**ADC Planning Consultation
Response from the Historic Buildings Adviser**

Application Number	A/39/13/L
Address	5 Long Back Cottages, Angmering
Description	Rear extension at ground and first floor level.
Case Officer	Anita Gardner
Site Visit	1 May 2013

PROPOSED

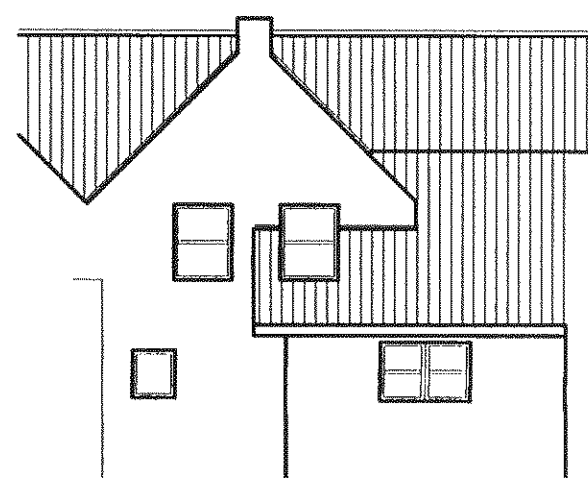
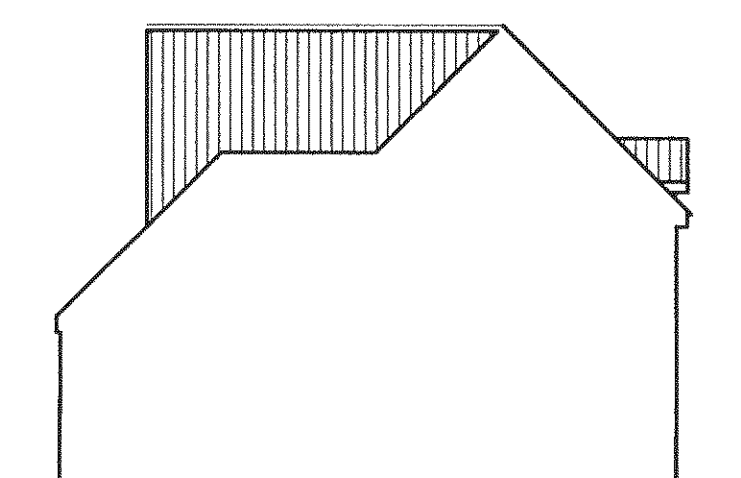
- Removal of an historic staircase.
- Loss of 2no historic doors related to staircase.
- Erosion of the ground floor plan due to opening up of living room.
- Loss of external walling to ground and first floors.
- Loss of historic outbuilding.
- Concealment of rear elevation.
- Inappropriate roof form encroaching on historic roof.
- Use of flat roof.
- Proposed stairs breaching historic envelope.
